Variation to Development Consent Order ref. TR050006.

Proposed non-material change to The Northampton Gateway Rail Freight Interchange Order 2019 (S.I. 2019 No.1358) .

Application made by Segro (Junction 15) Limited

Consultation on proposed non-material amendment

NGW-BWB GEN XX-SK-C-SK315–S2-PO1

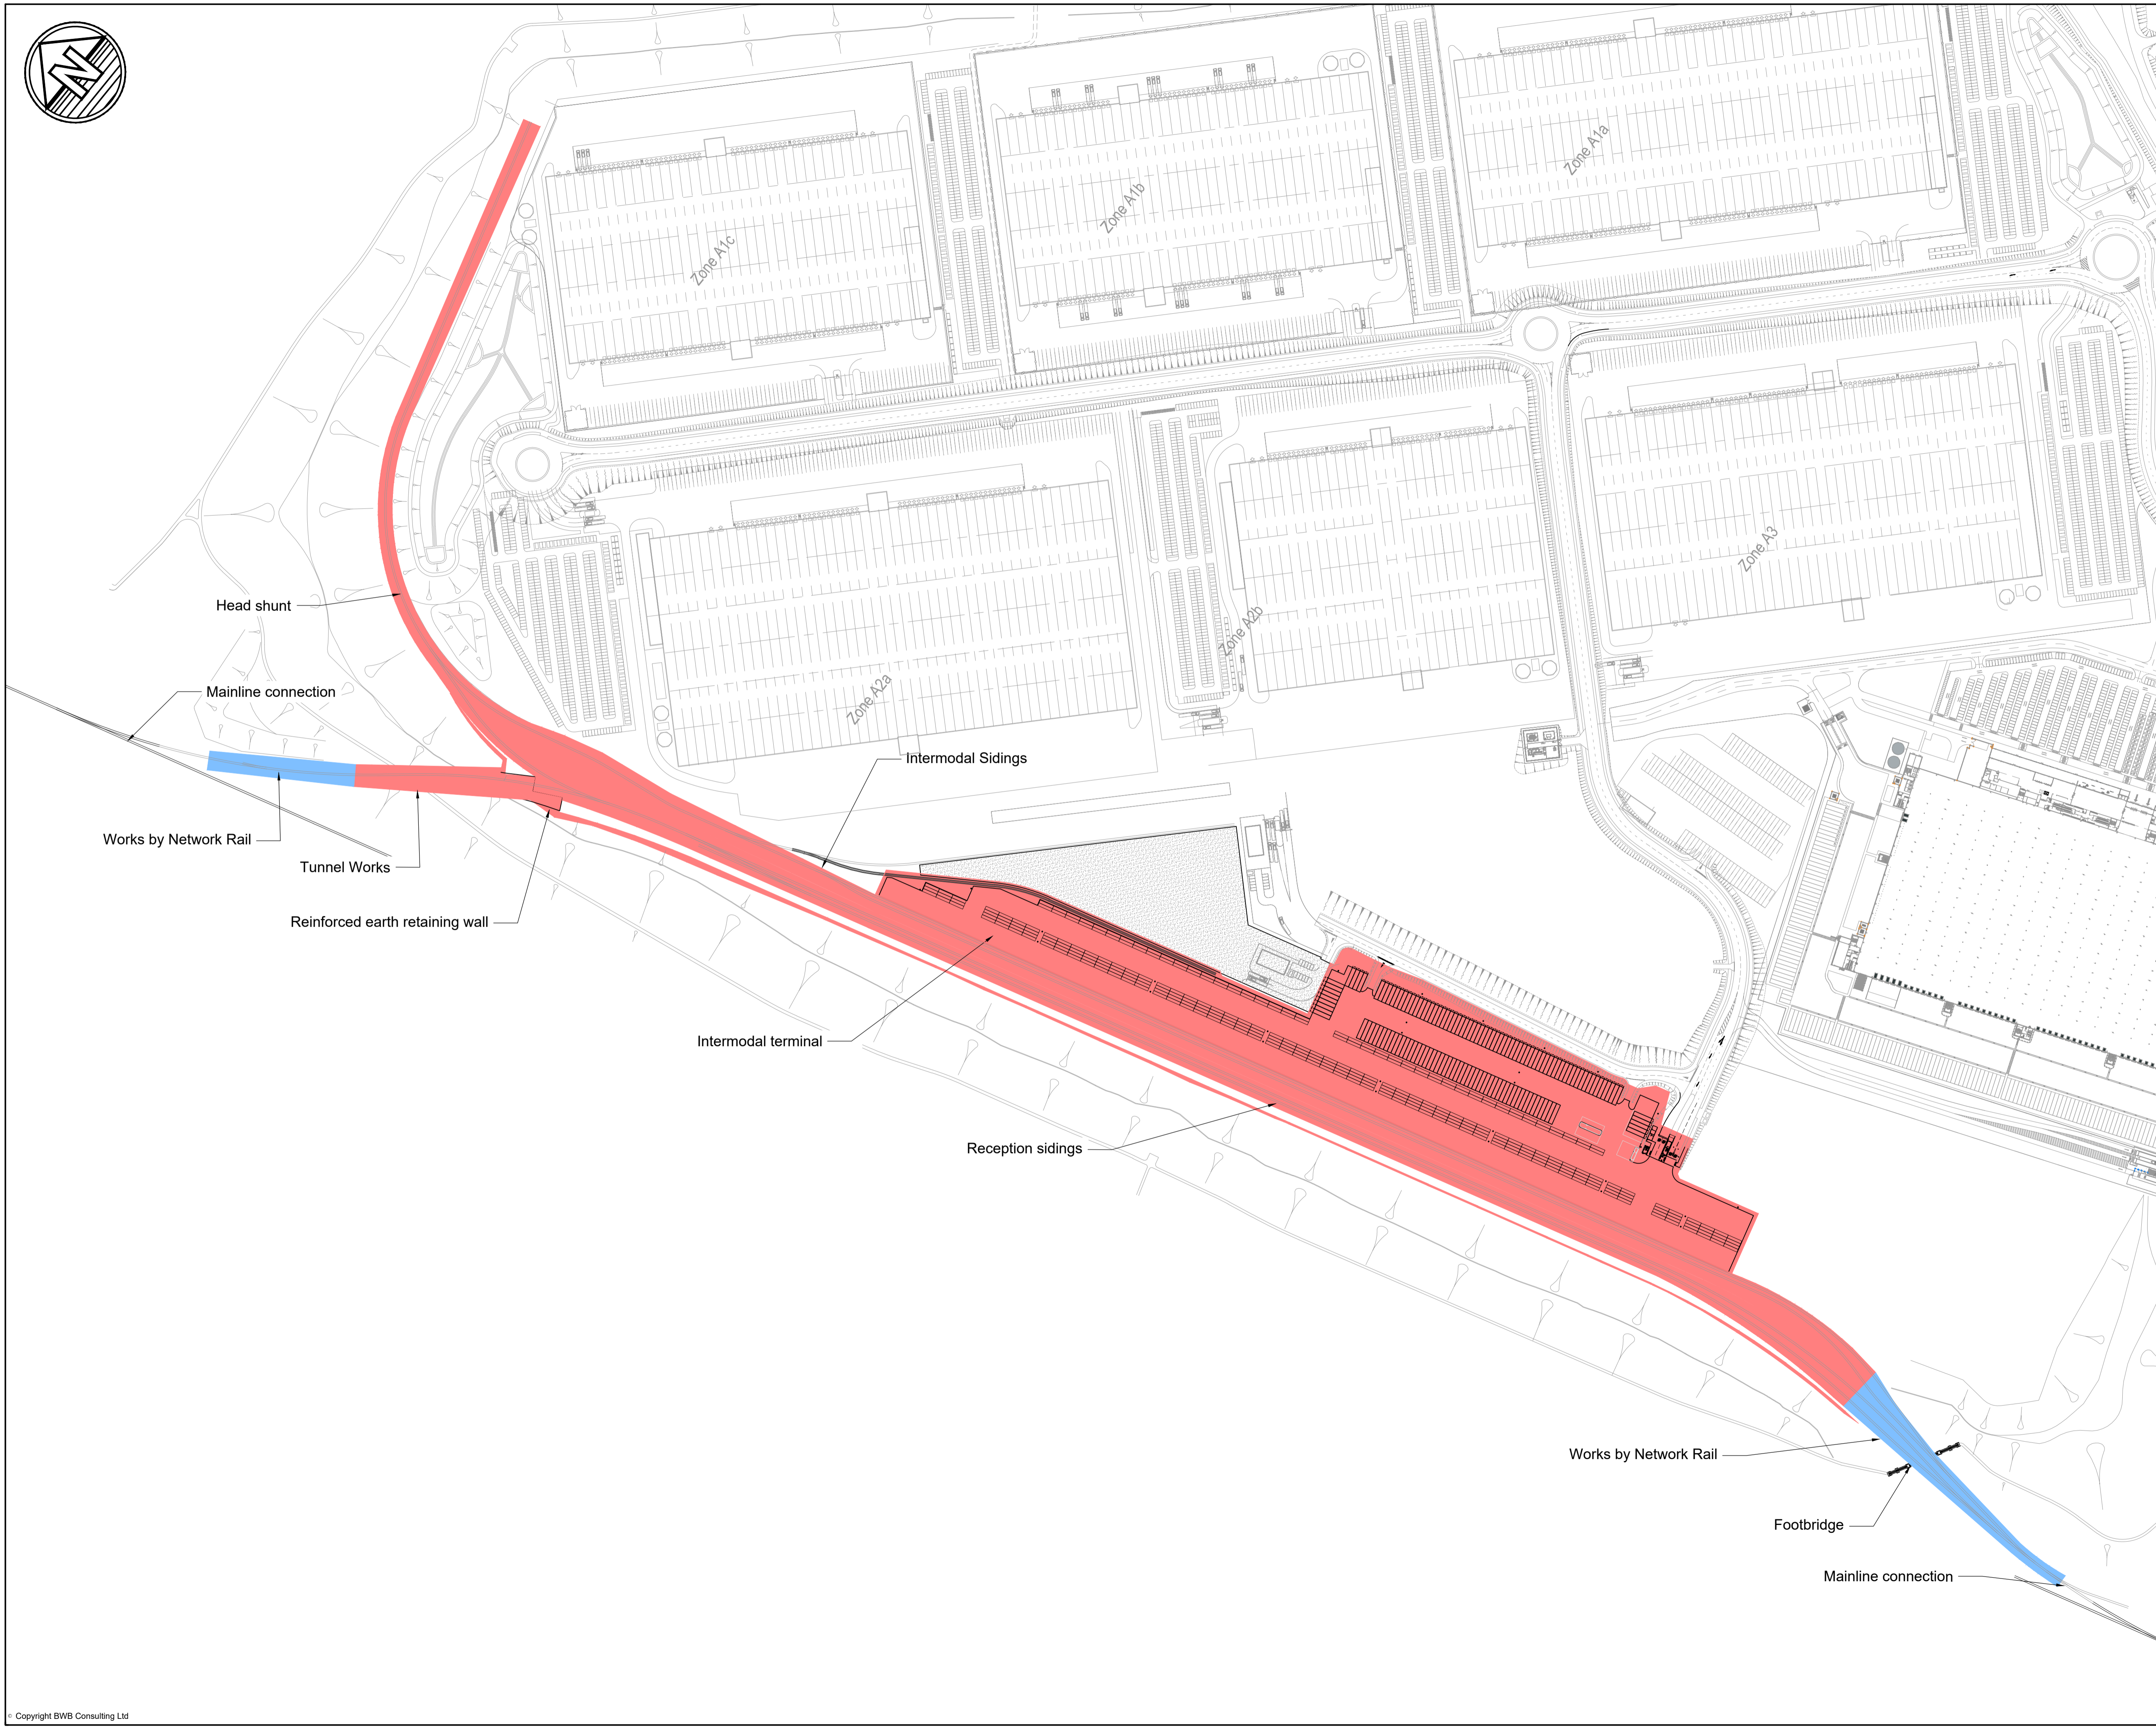
6. by introducing a new ‘rail infrastructure plan’, reference (NGW-BWB-GEN-XX-SK-C-SK315-S2-P01), to the list of approved documents and plans in Schedule 16 to the Order, this plan omits the rail connections to be provided by Network Rail from the rail infrastructure to be completed prior to the occupation of the specified warehouse floorspace.

7. The effect of the above variations will be to allow the occupation of up to 232,260 square metres of floorspace within the ancillary warehousing buildings, which can be provided within the area defined on the approved parameters plan, prior to the rail freight interchange terminal becoming operational, i.e. prior to the completion of the works required to connect the rail infrastructure to be provided by the applicant, SEGRO (Junction15) Ltd to the wider rail network.
